Please ask for Mr G Hynds
Our Ref GH/S746/04
Your Ref EG/22/15/PL

S.746 EASTERGATE UV & TURBIDITY MITIGATION SCHEME – APPLICATION FOR REMOVAL OR VARIATION OF A CONDITION FOLLOWING GRANT OF PLANNING PERMISSION

27-655-M-3030

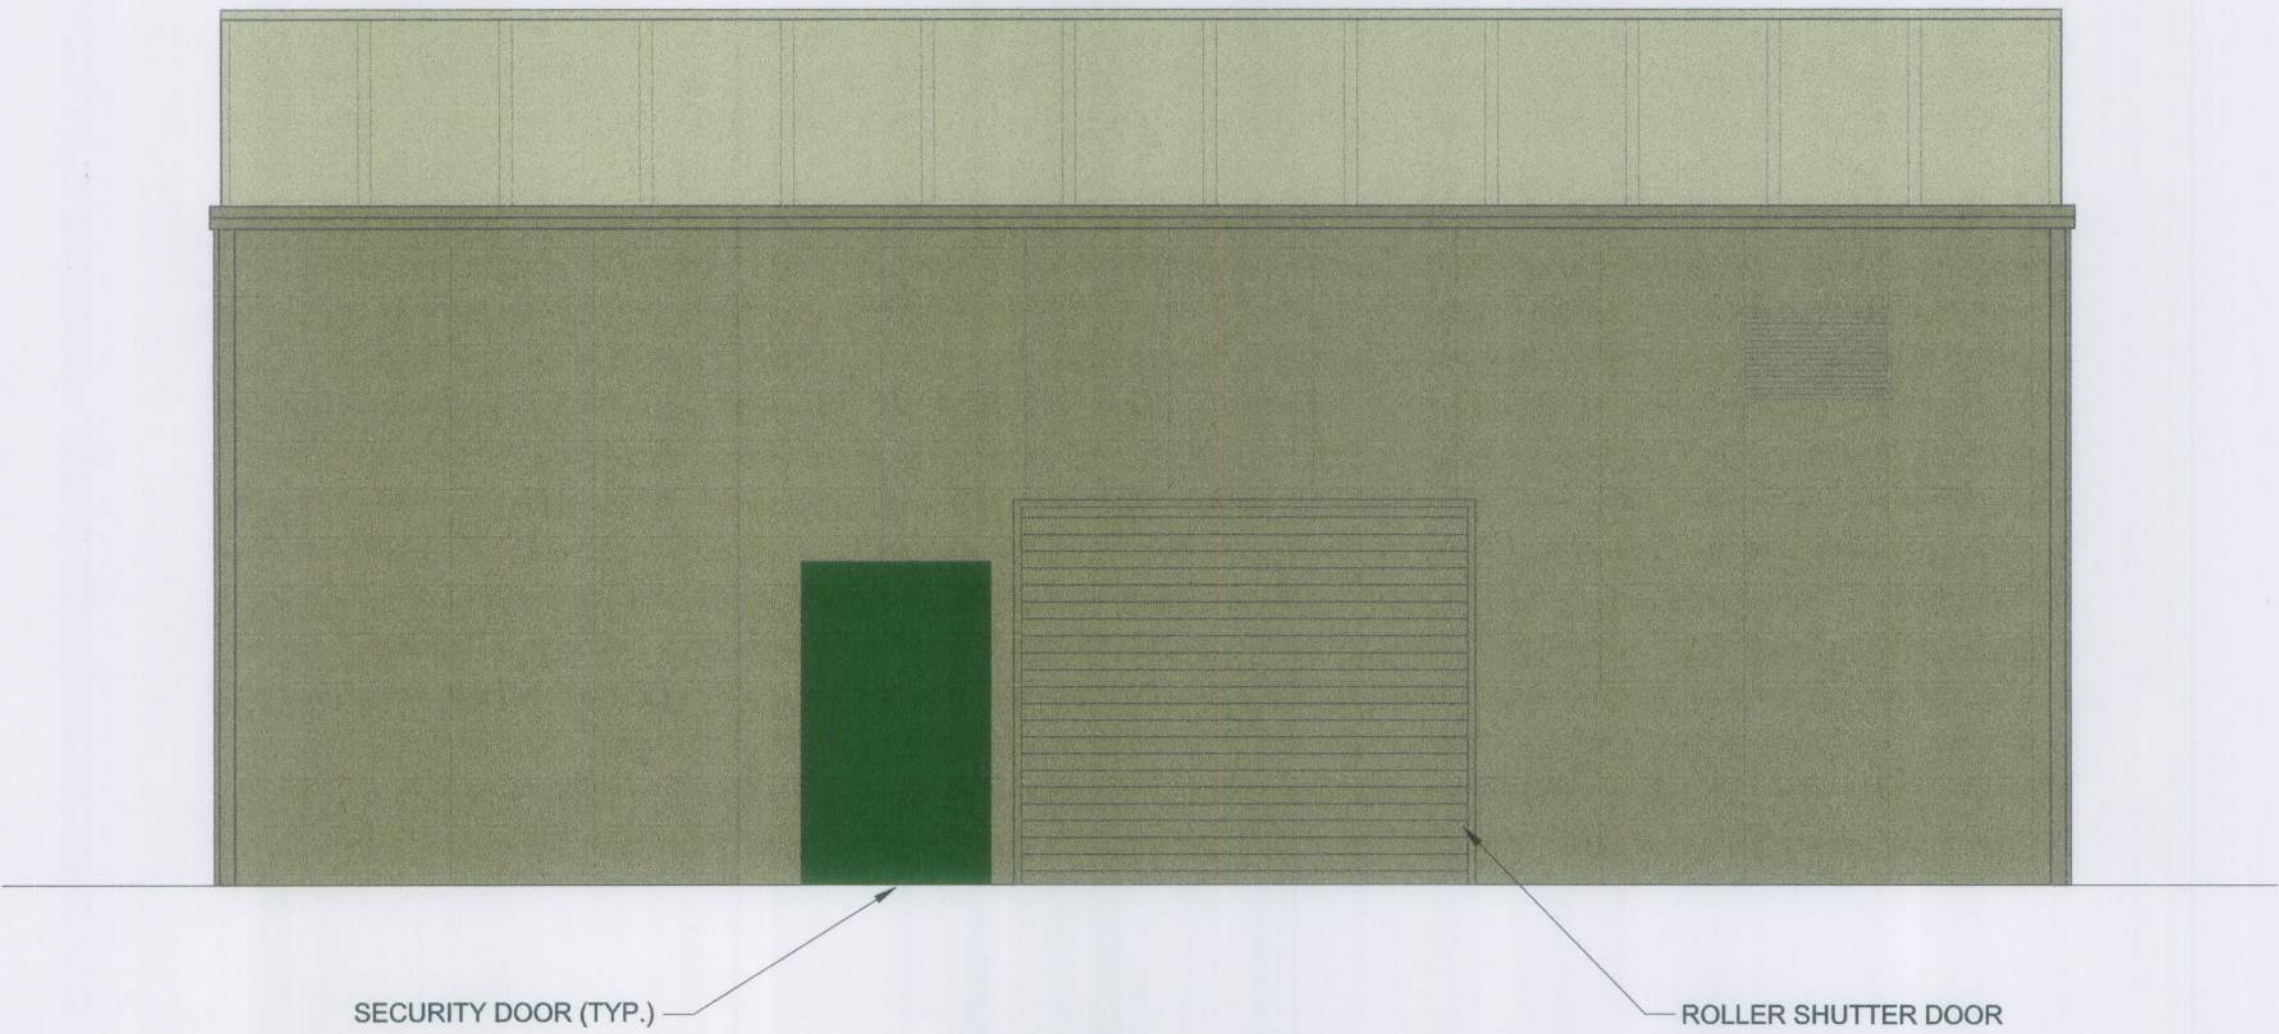
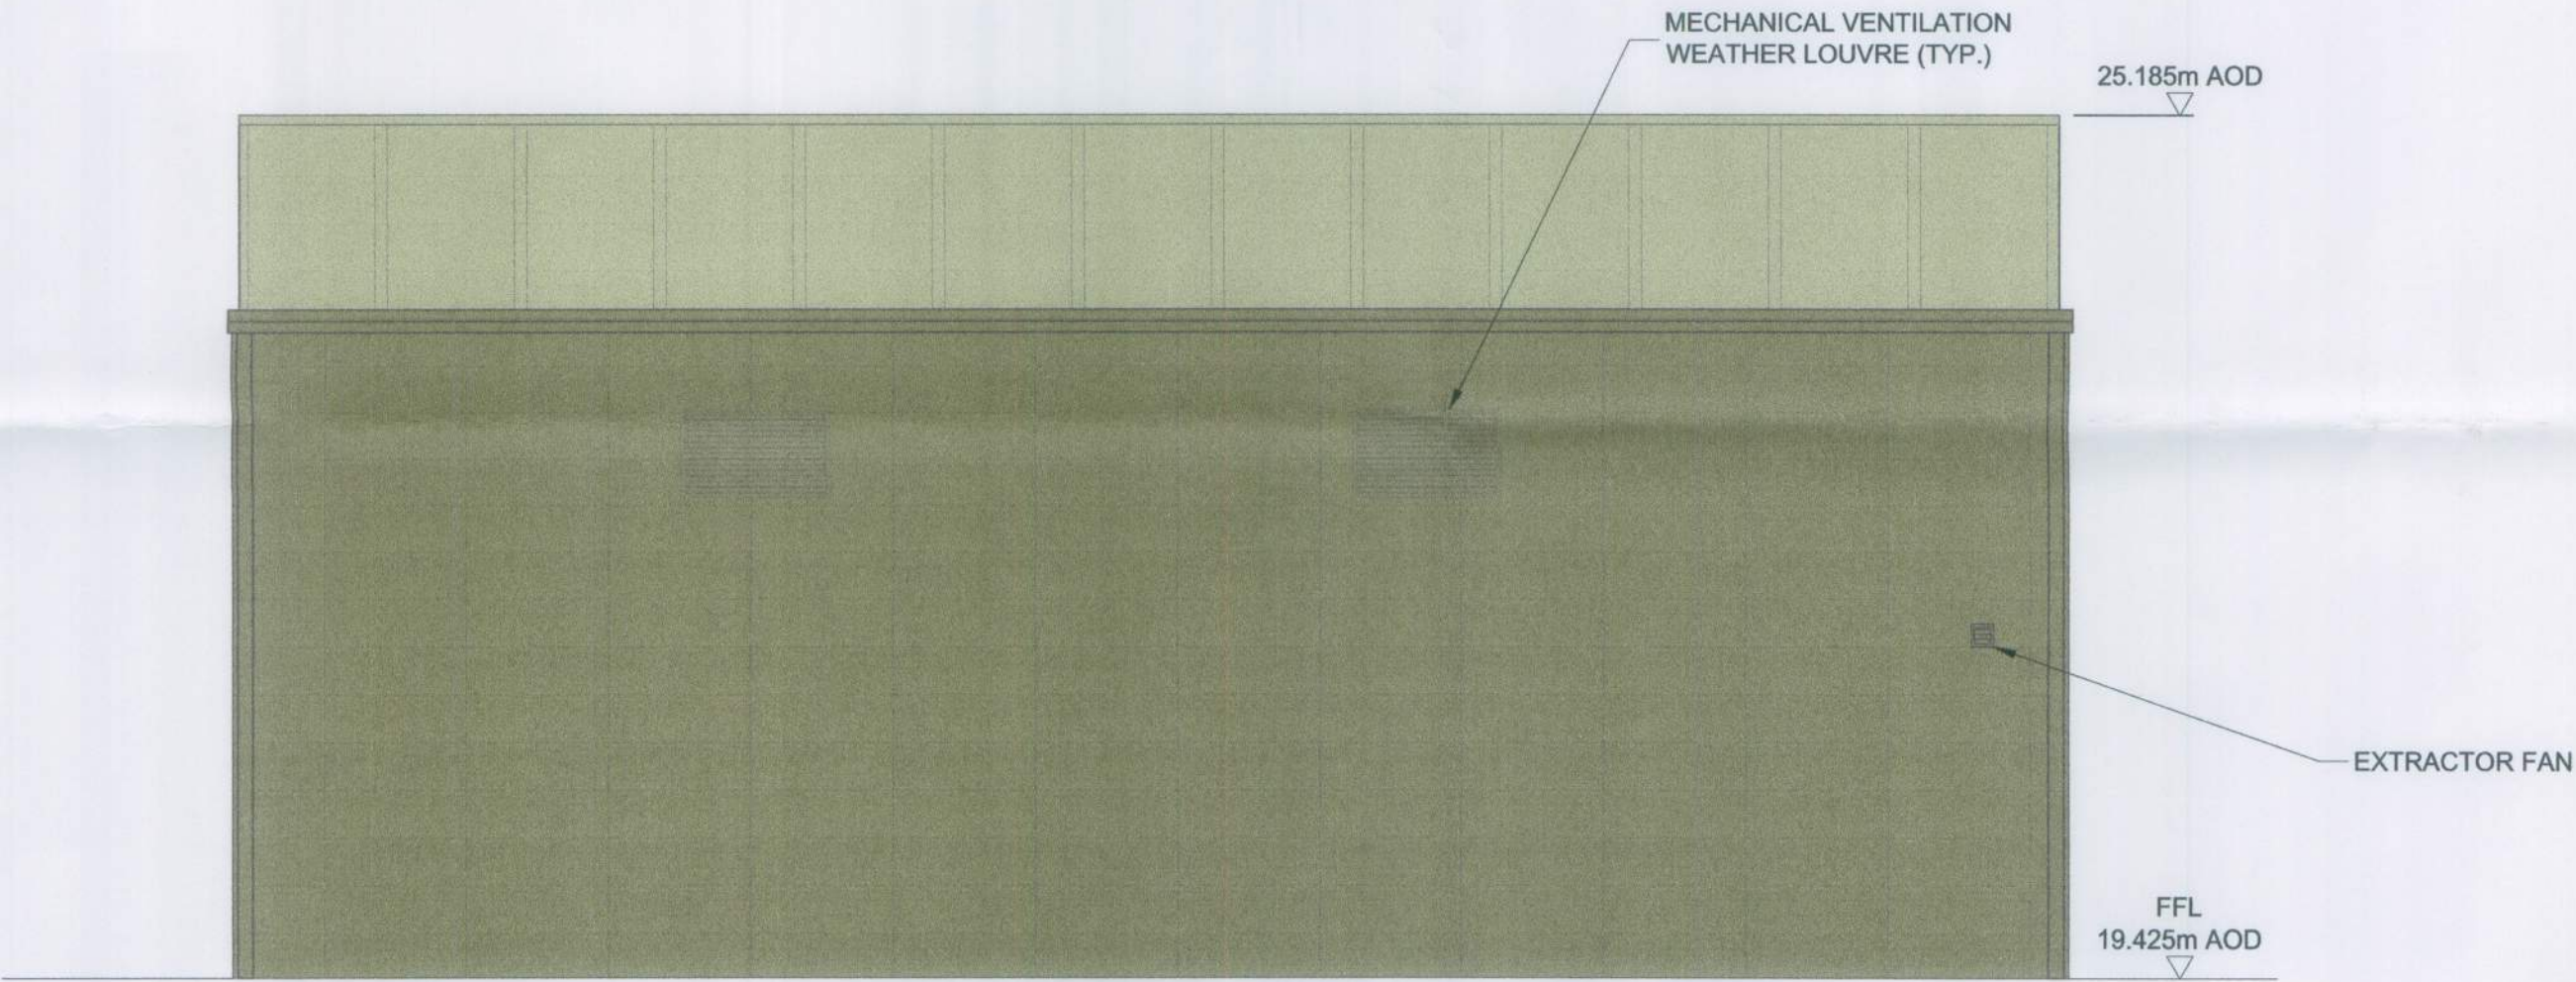
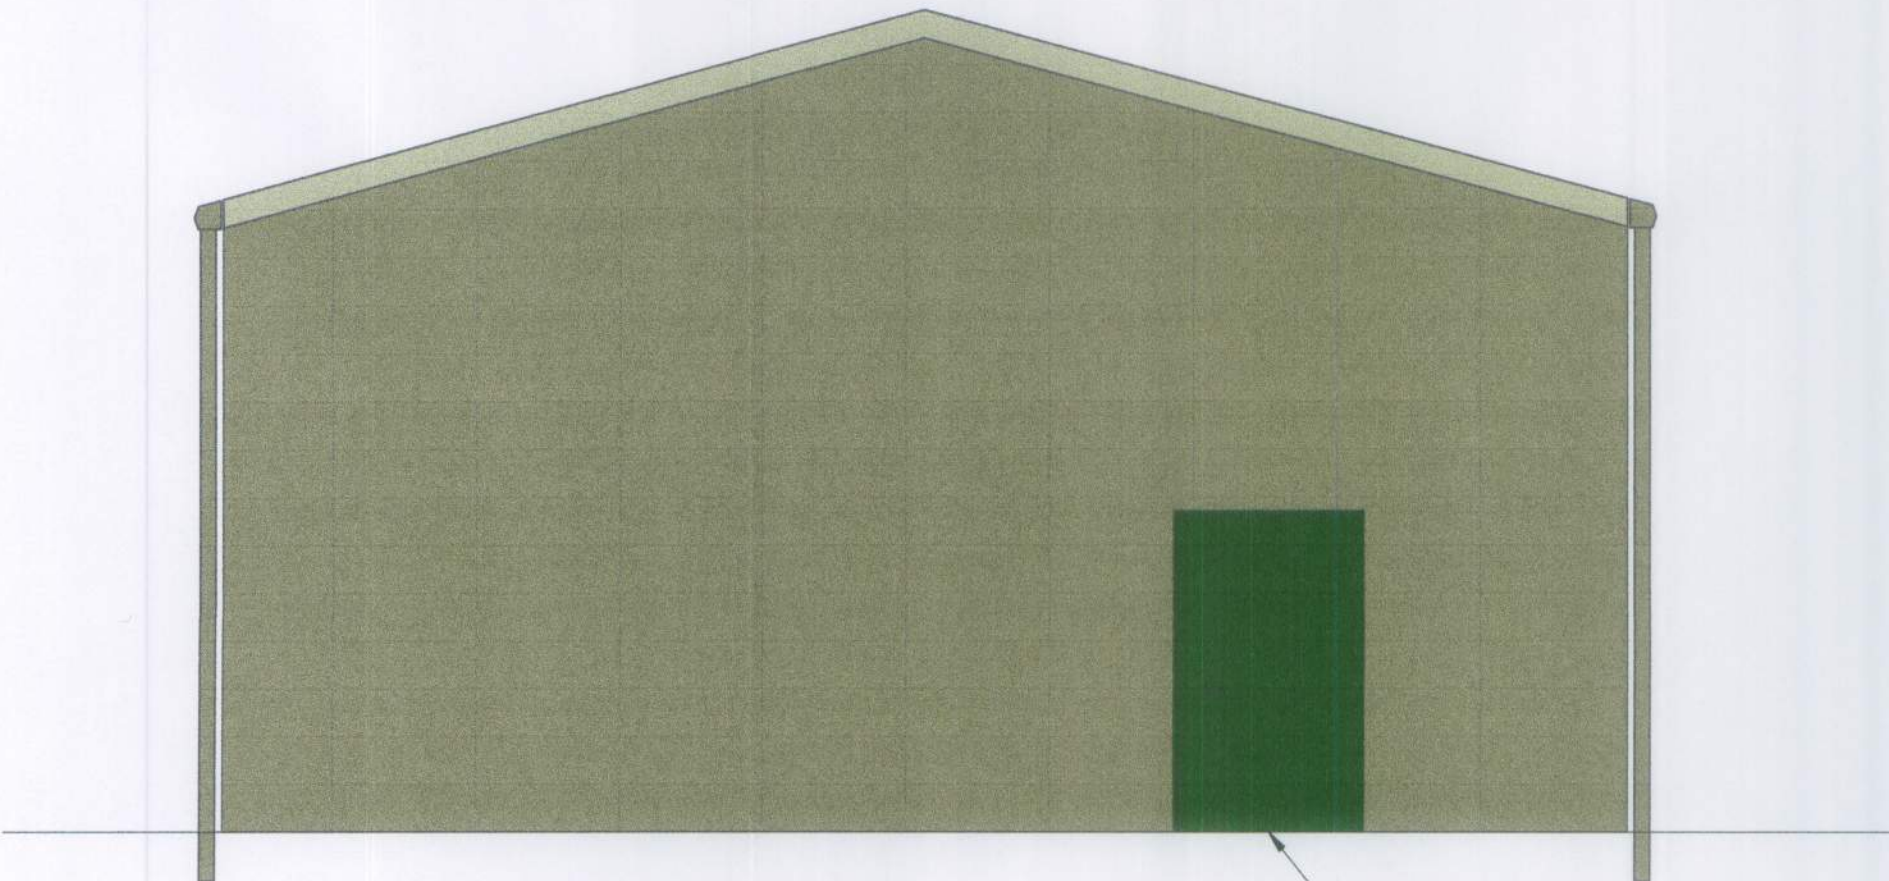
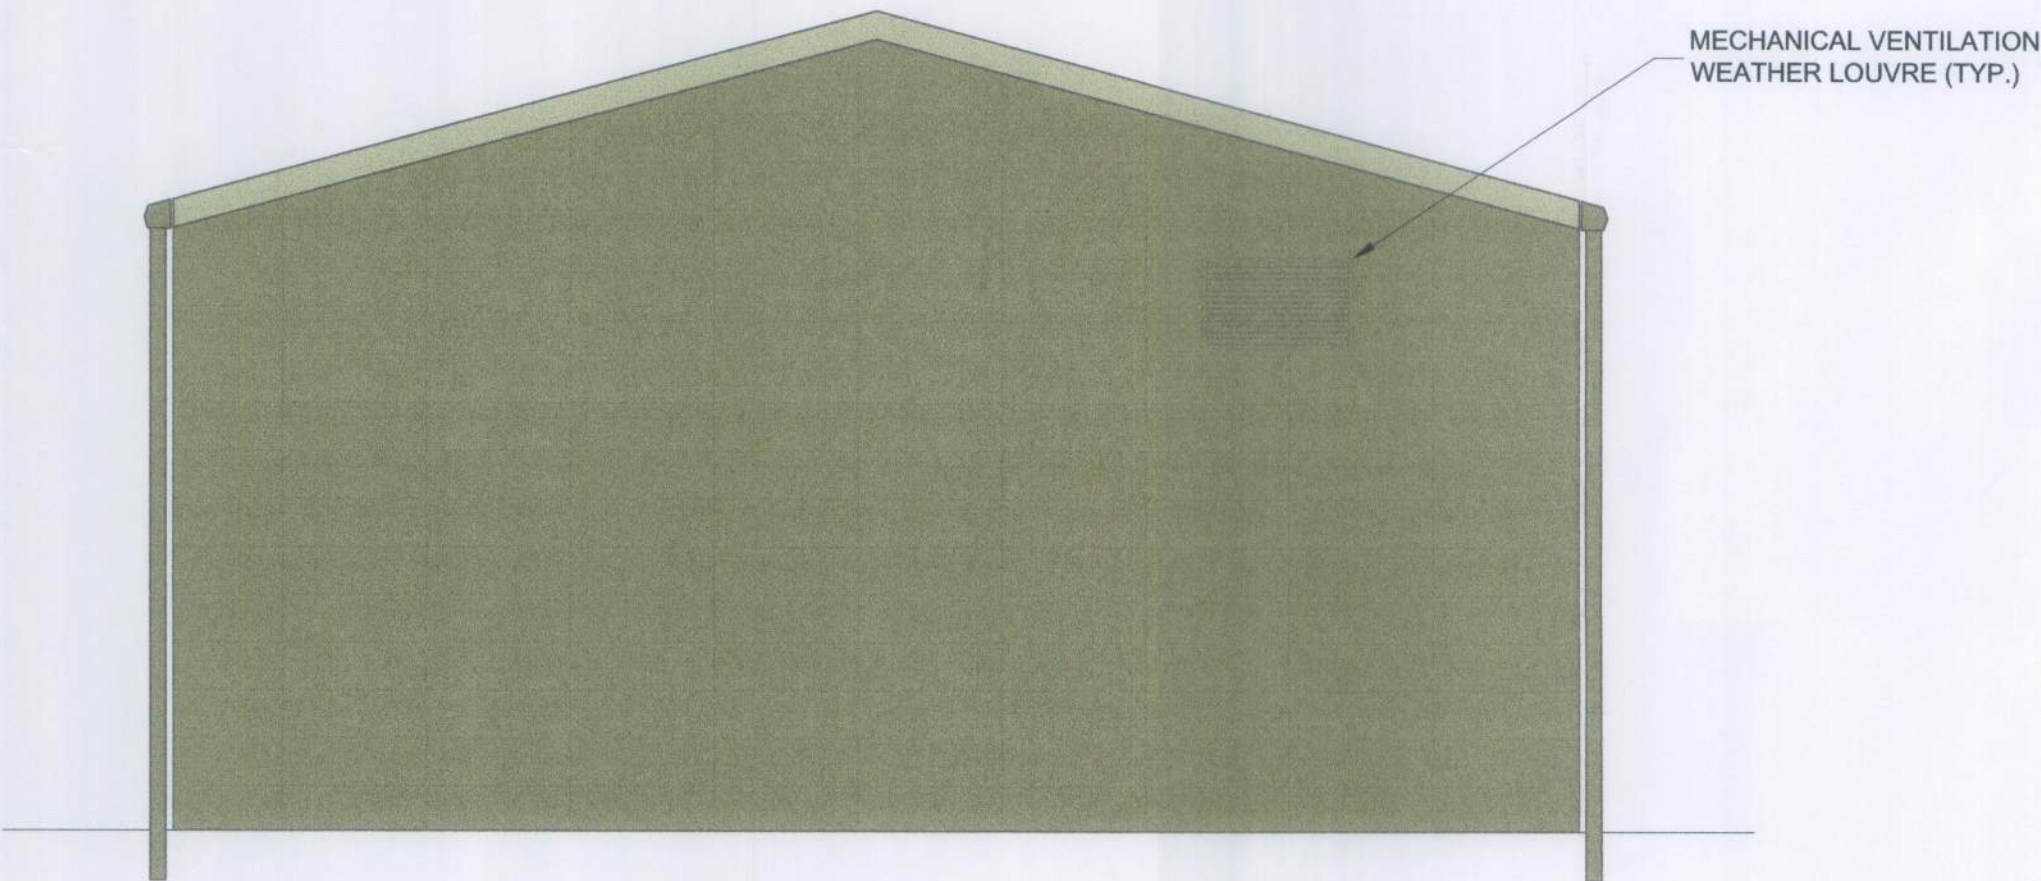
1. The colour of the building is shown on drawings 27-5132699-031. The drawing indicates the walls to be 'Olive Green' (RAL 100 30 20) and the roof to be 'Goose Green' (RAL 7038). This does not align with our PDA statement, item 5.7.3 and needs to be altered accordingly as these panels have now been purchased and fitted on site. The revised colours are shown on drawing number 27-655-M-3030 Rev A.

1. Alter the colours of the building to 'Khaki Green' (RAL 100 60 20) for the walls, 'Willow Green (RAL 100 80 20) for the roof and 'Leaf Green' (RAL 6002) for the doors.
